CITY OF MERCER ISLAND

RE: SUB19-003, CAO19-005, SEP19-009 Lady Bug Trust **Request for Information #2**
Consolidated Land Use Applications for a subdivision of one lot into two lots, extinguish and create new easements, and steep slope alteration located within the shorelands.

OGDEN POINT SHORT PLAT
 SITE PLAN
 THE LADYBUG TRUST
OGDEN POINT SHORT PLAT
 WASHINGTON
 CITY OF MERCER ISLAND,

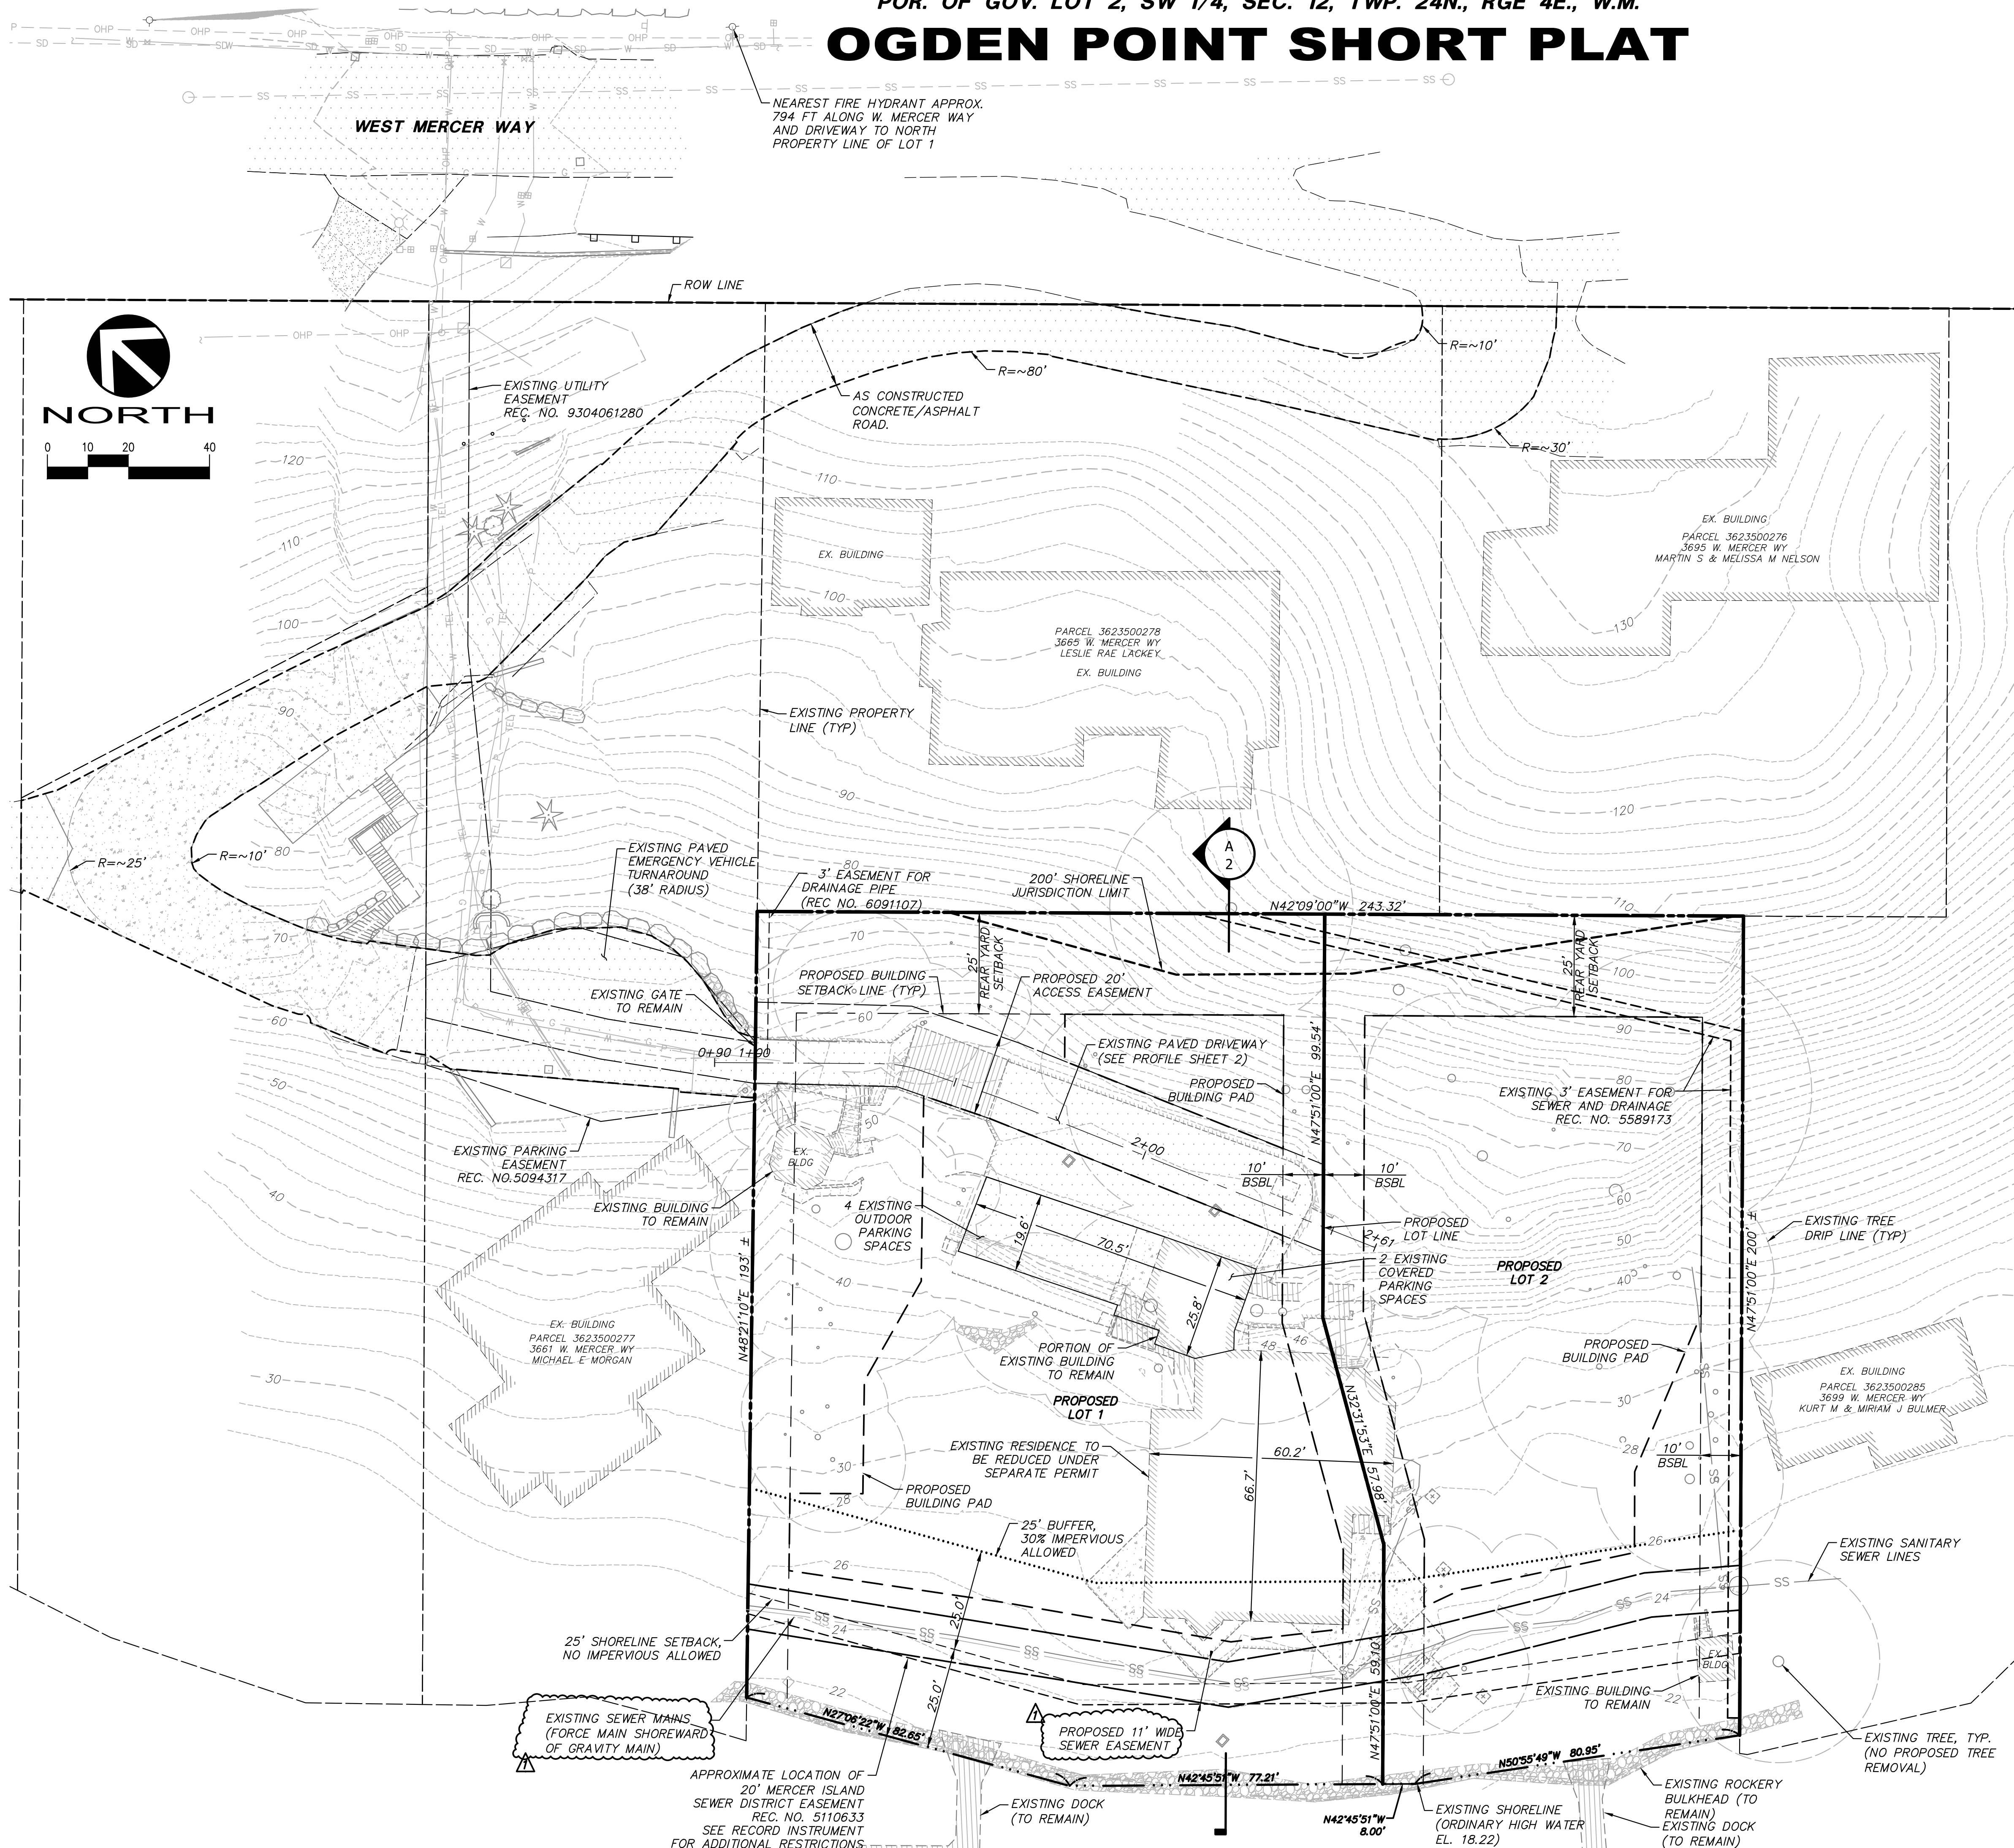
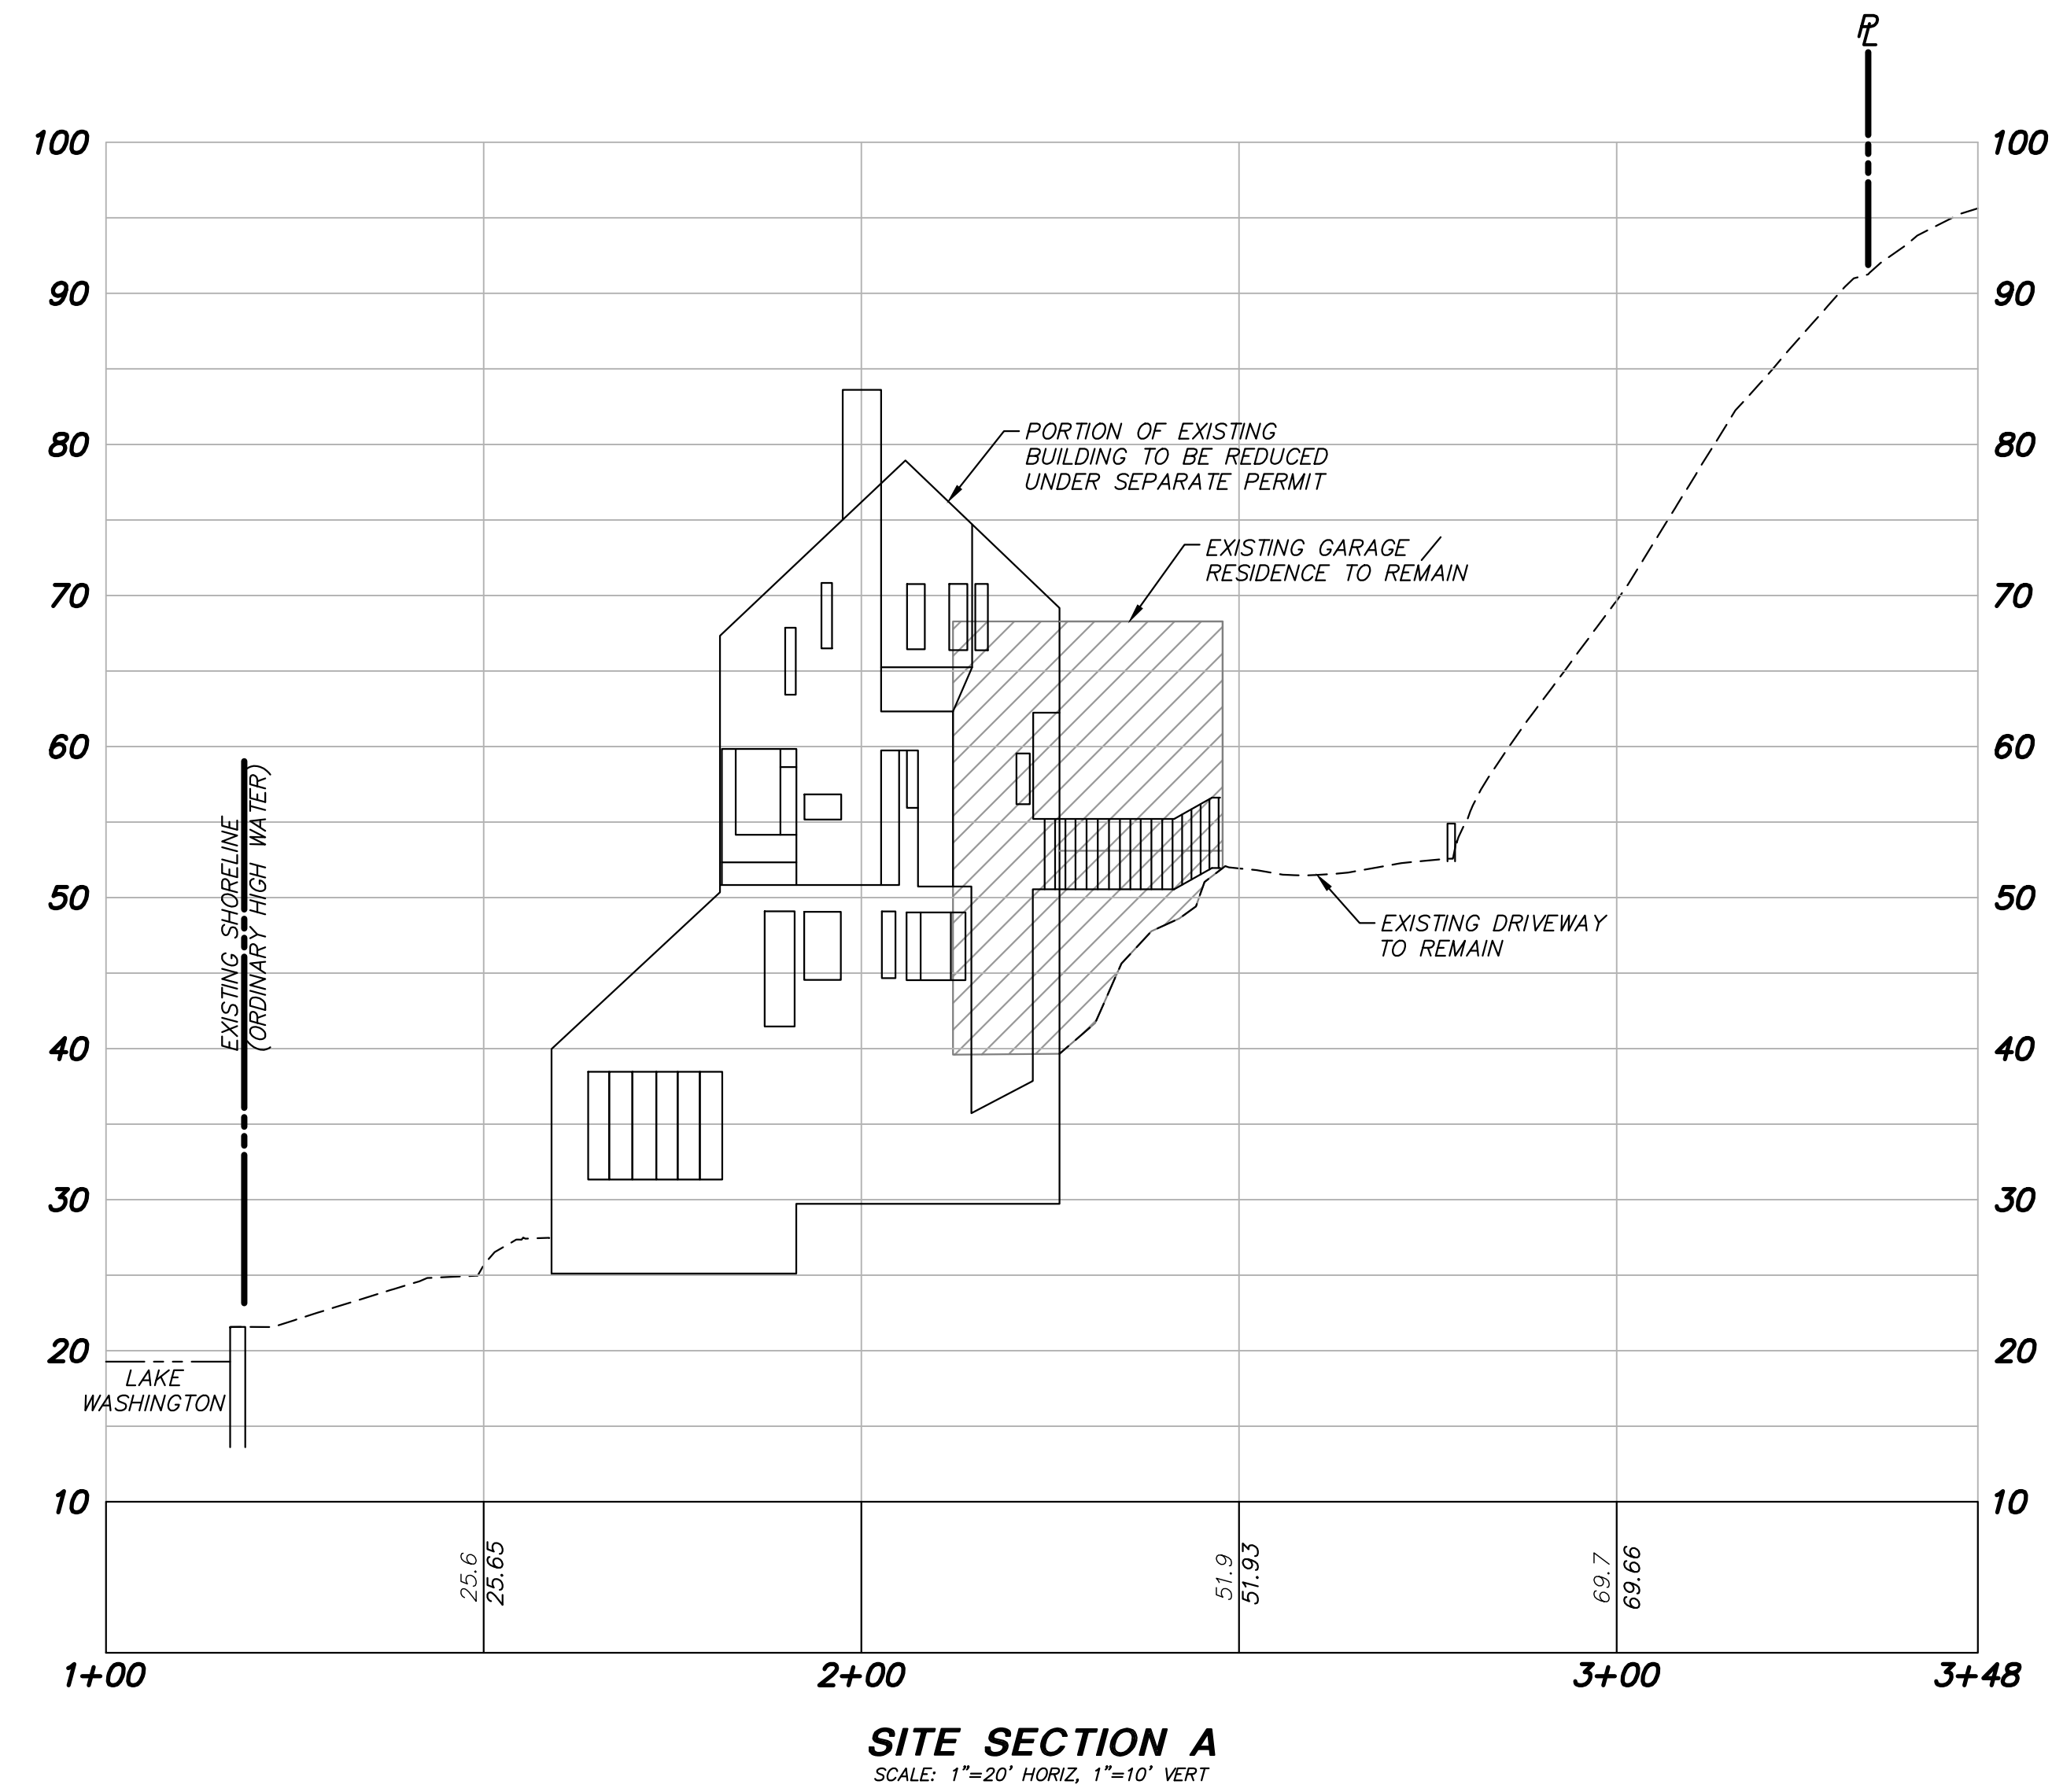
- e. How the driveway will comply with MICC 19.09.040, particularly (G) Gradient.
3. Per our discussion on Tuesday June 25th, in order to not go through Site Development until the building permit, the lot line in-between Lot 1 and Lot 2 would abut the edge of the existing driveway and retaining wall. Please revise the plans and move the lot line to the west.

4. No cross-section dimension of a designated building pad shall be less than 20 feet in width, please revise the area labeled "Lot 1 Building Pad #2" to only include the area that meets the minimum width requirement per MICC 19.08.030(E)(3).
